**From:** Simon Davis <Simon.Davis@arun.gov.uk>  
**Sent:** 29 January 2021 10:53  
**To:** Planning.Responses <Planning.Responses@arun.gov.uk>  
**Subject:** Cinders Nursery Phase 2 ref Y/140/20/DOC

Final drainage comments

**Subject:** RE: Cinders Nursery Phase 2, Cinders Lane: Planning Consent Y/32/17/OUT

HB1, Hydro Brake Manhole & Discharge from Sub Base Attenuation Details

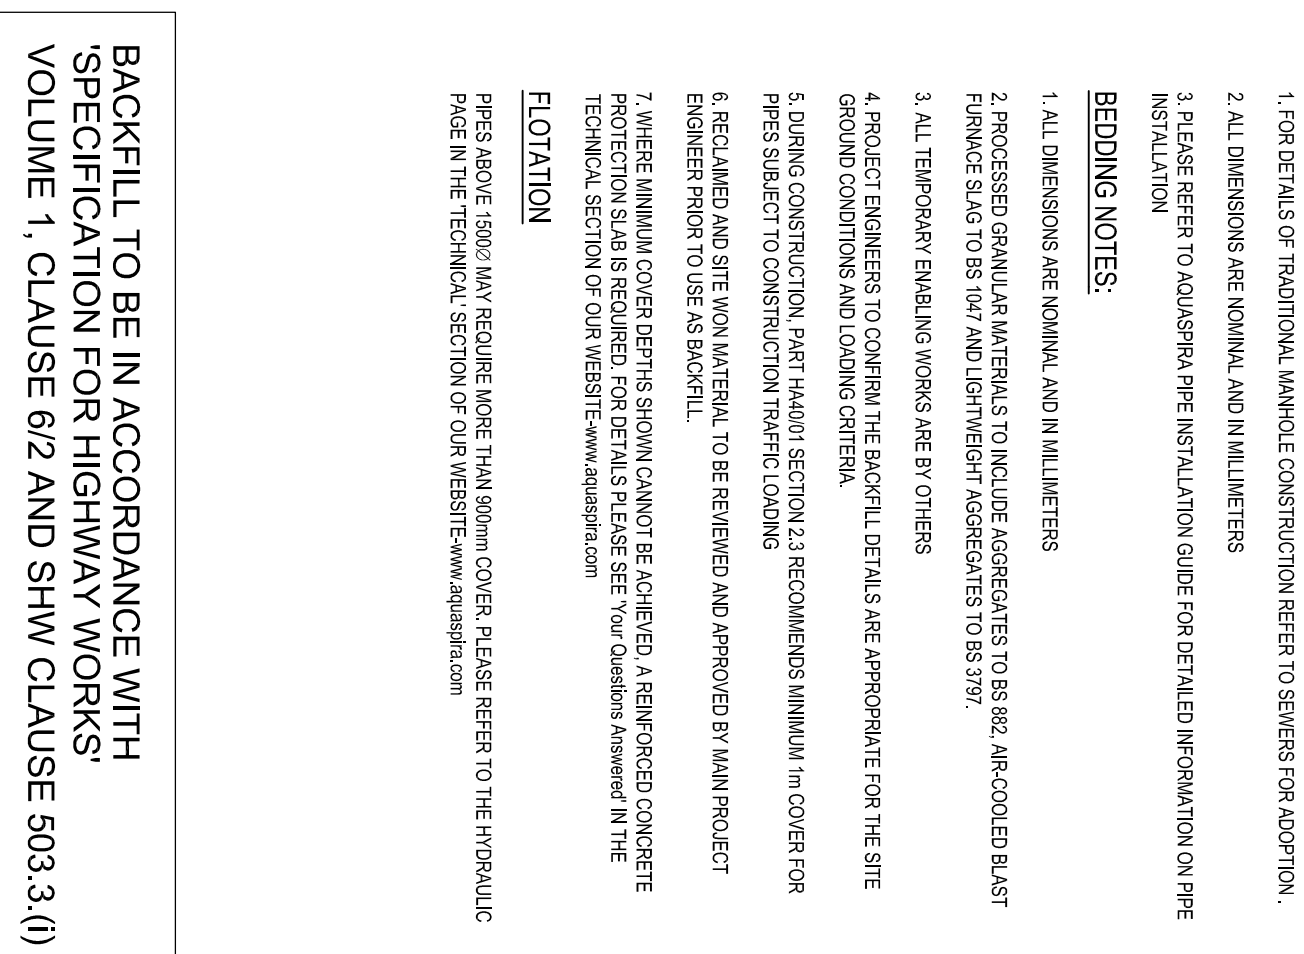
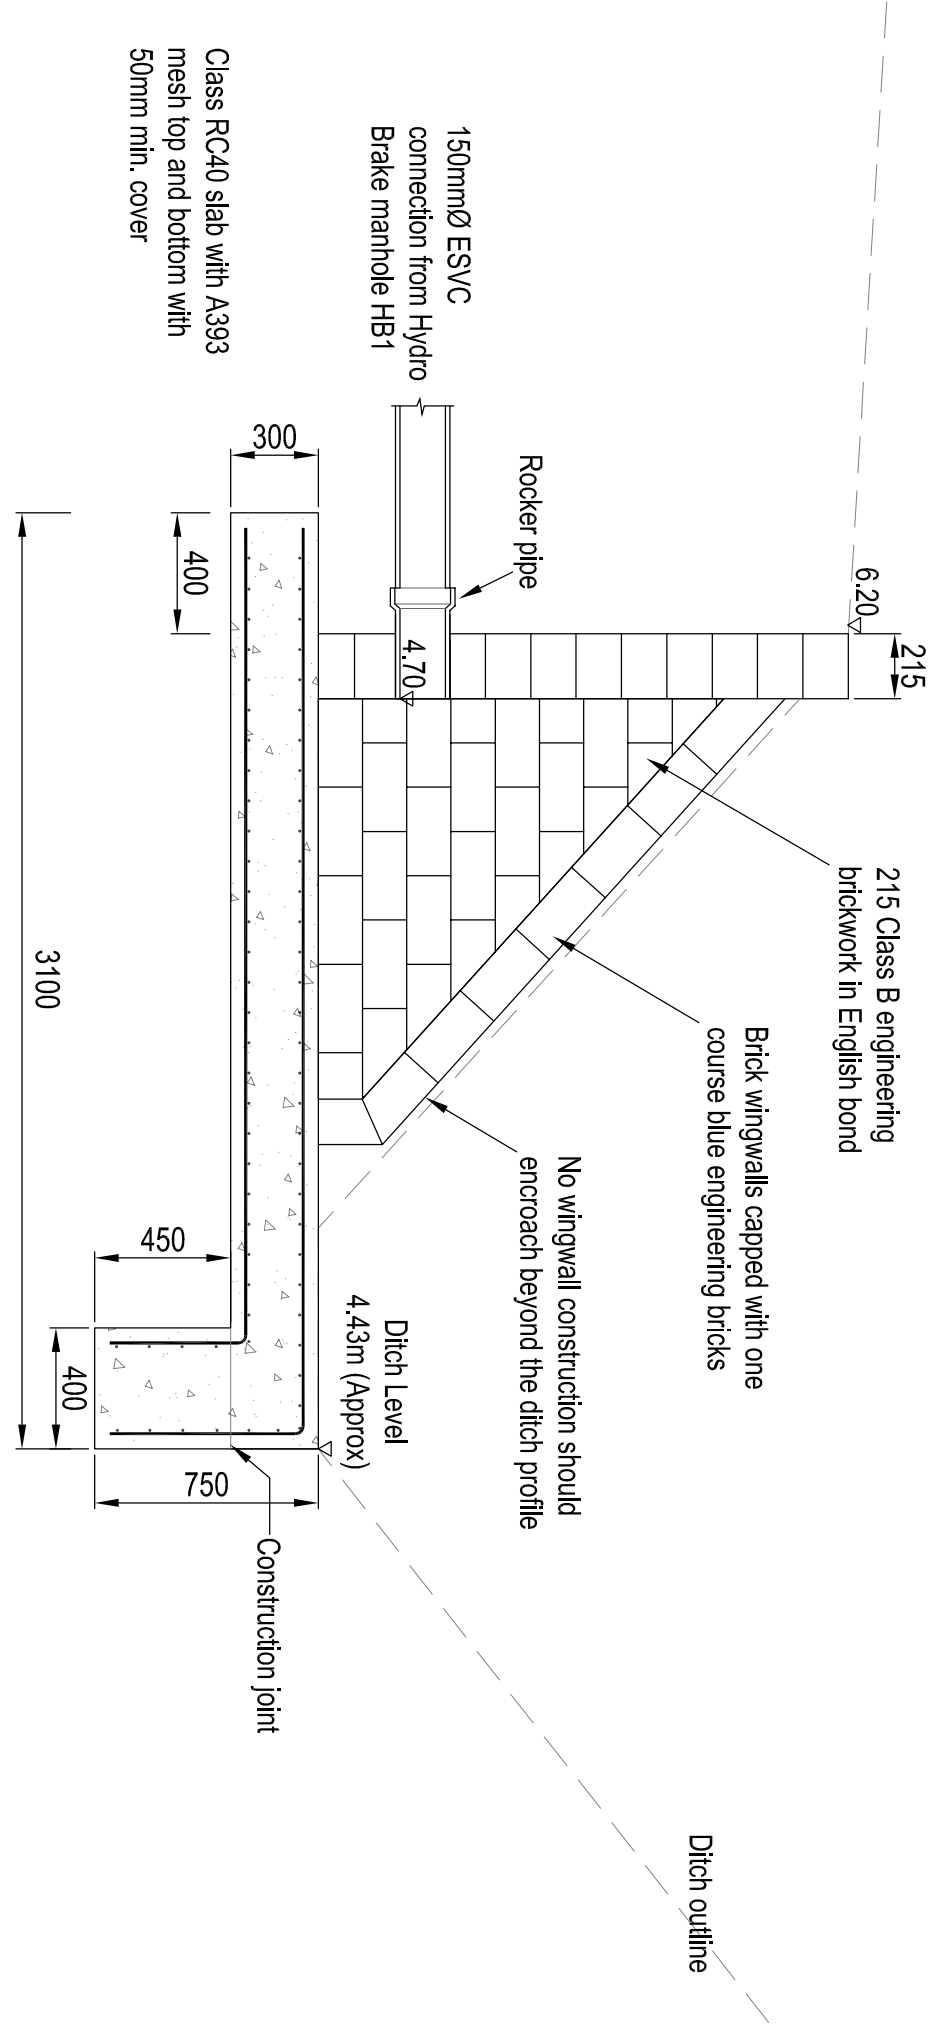
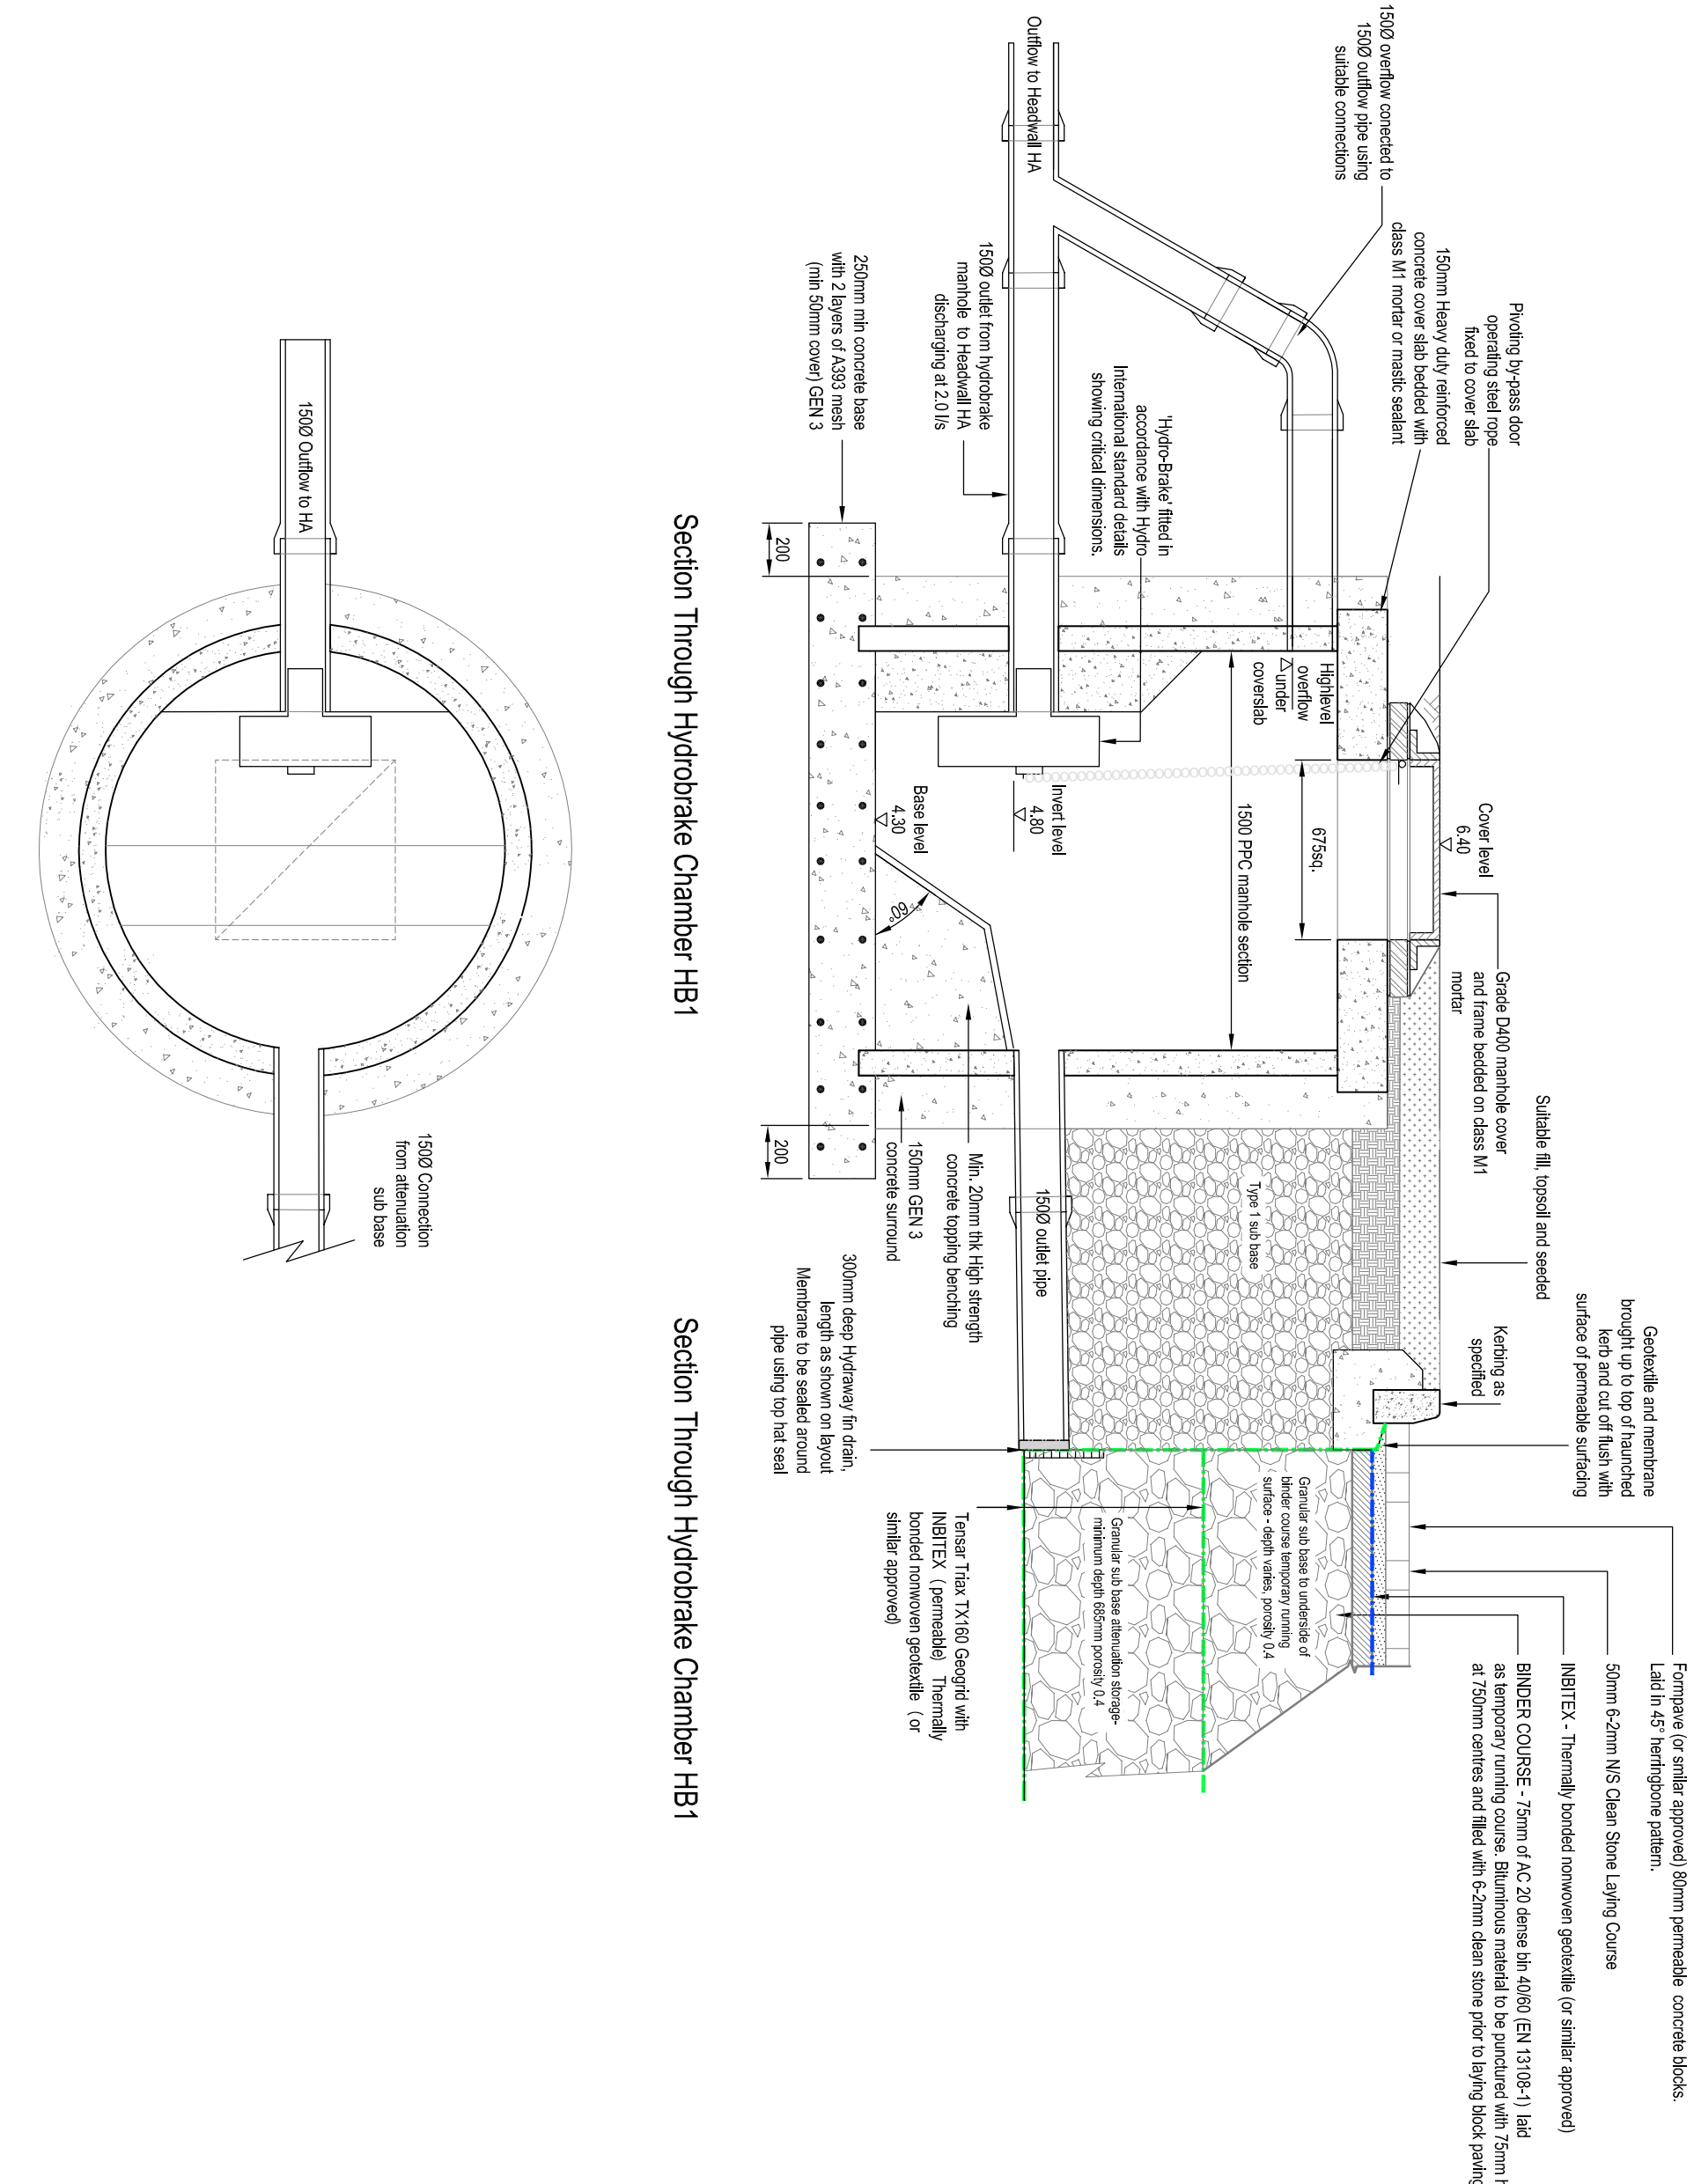
28. Specify hydrobrake model on HB1 construction detail drawing. Specify ST4 concrete base, benching and block for hydrobrake fixing. Specify overflow invert level and surround pipe in min. 150mm thick ST4 concrete. Include step rungs. Specify class B engineering brickwork under cover/frame. Hydro Brake model specified and all other comments incorporated on drg KNC2006-501-03 Rev B ok but alter reference to headwall HA to H2.

28. Specify hydrobrake model on HB1 construction detail drawing. Specify ST4 concrete base, benching and block for hydrobrake fixing. Specify overflow invert level and surround pipe in min. 150mm thick ST4 concrete. Include step rungs. Specify class B engineering brickwork under cover/frame. Hydro Brake

model specified and all other comments incorporated on drg KNC2006-501-03 Rev B ok but alter reference to headwall HA to H2. Outfall reference has been amended to H2, revised drawing KNC2006-501-03-C attached.

Drawing Title				
Engineering Details				
Standard Construction Details				
Drawing	Contract	Scale	Paper Size	Date
KN		As Shown	A1	12.18
Job No.	Drawing No.		Revision	
KNC2006	501-01		B

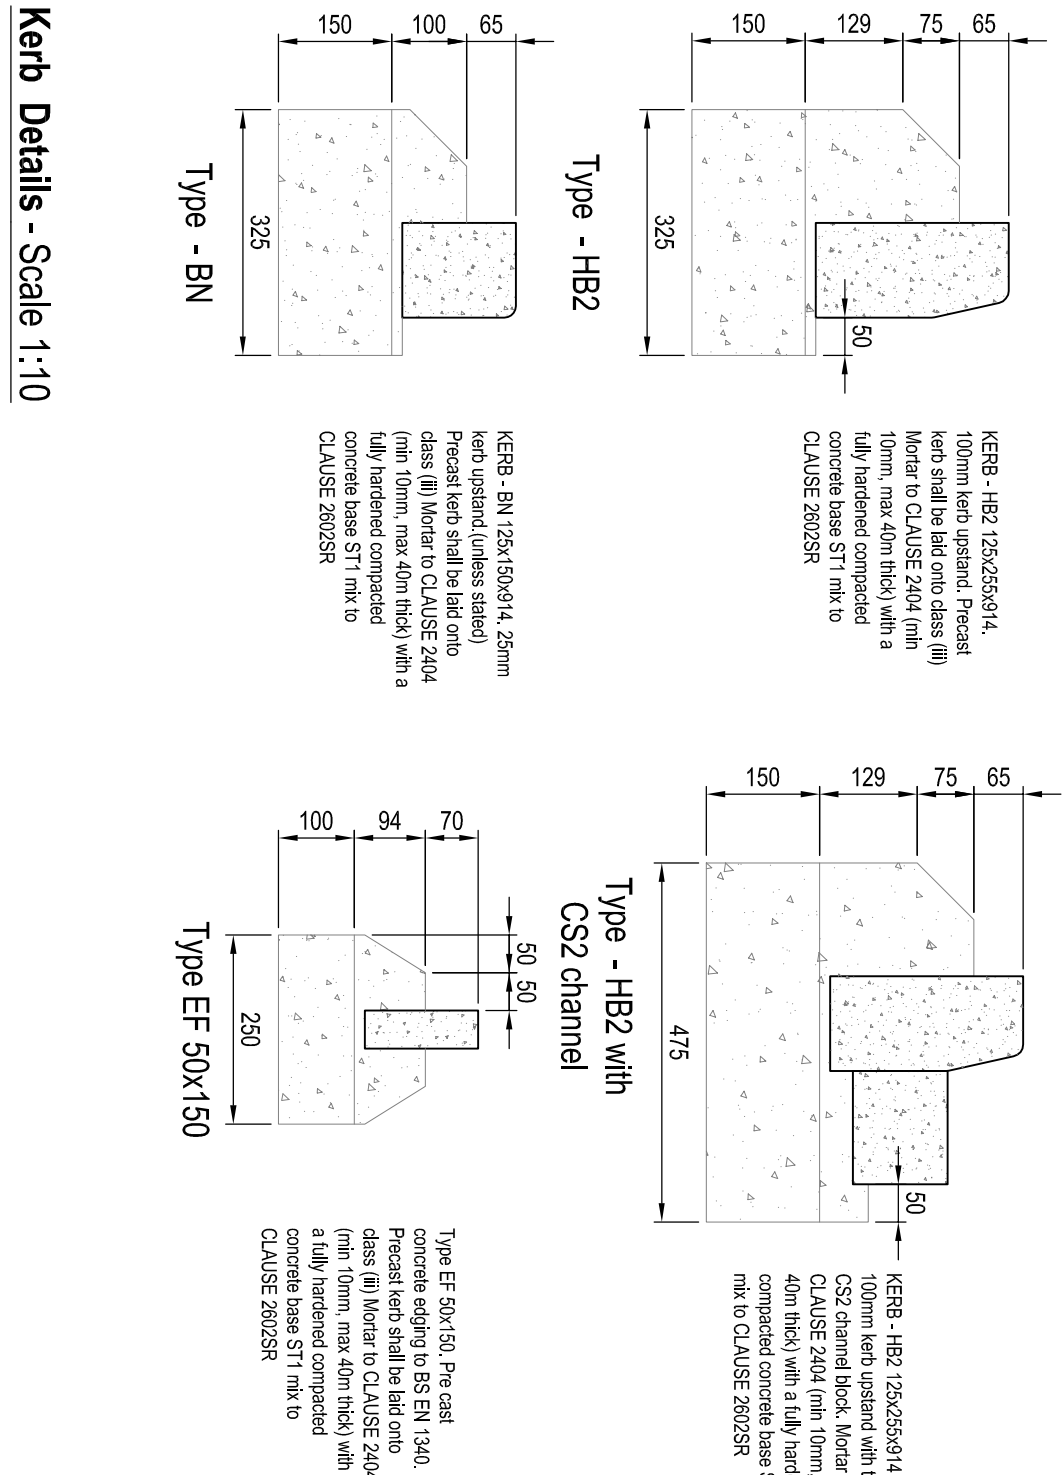
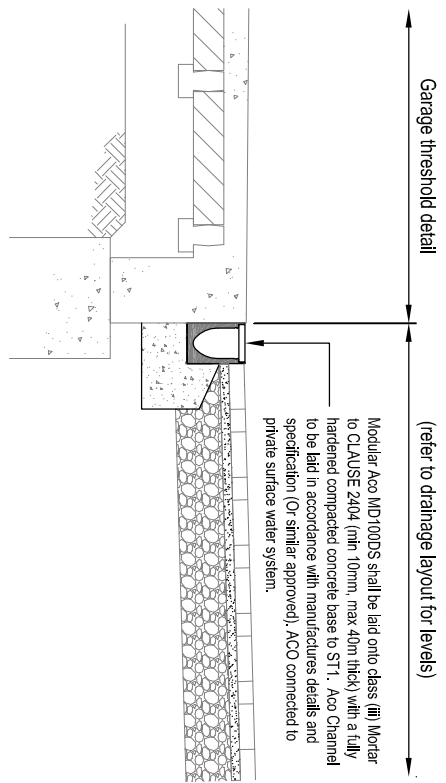
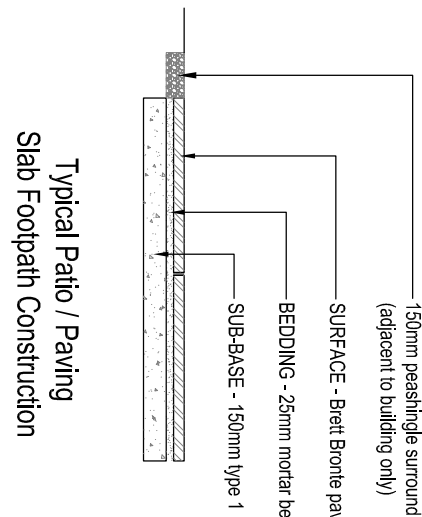
26. Drawing 501-03 Rev A - Aquire Spire storage pipe detail not relevant – delete. This detail has been removed from the drawing ok
27. Drawing 501 01 Rev B – permeable block paving detail type 3 not relevant? – delete There is an area of permeable block paving which is situated at the eastern end of the site and in the lay-bys. It is identifiable on the drainage layout and also on the attached surfacing drawing KNC2006-507-01 Rev B. Noted but type 1 material is specified within the construction which is not permeable ie. how does water reach the attenuation sub base? I assume this is a typo as drg. KNC2006/501-03 Rev B shows a porous granular sub base.

27. Drawing 501 01 Rev B – permeable block paving detail type 3 not relevant? – delete There is an area of permeable block paving which is situated at the eastern end of the site and in the lay-bys. It is identifiable on the drainage layout and also on the attached surfacing drawing KNC2006-507-01 Rev B. Noted but type 1 material is specified within the construction which is not permeable ie. how does water reach the attenuation sub base? I assume this is a typo as drg. KNC2006/501-03 Rev B shows a porous granular sub base. Your comments are correct, drg KNC2006-501-01-D has been amended and is attached.
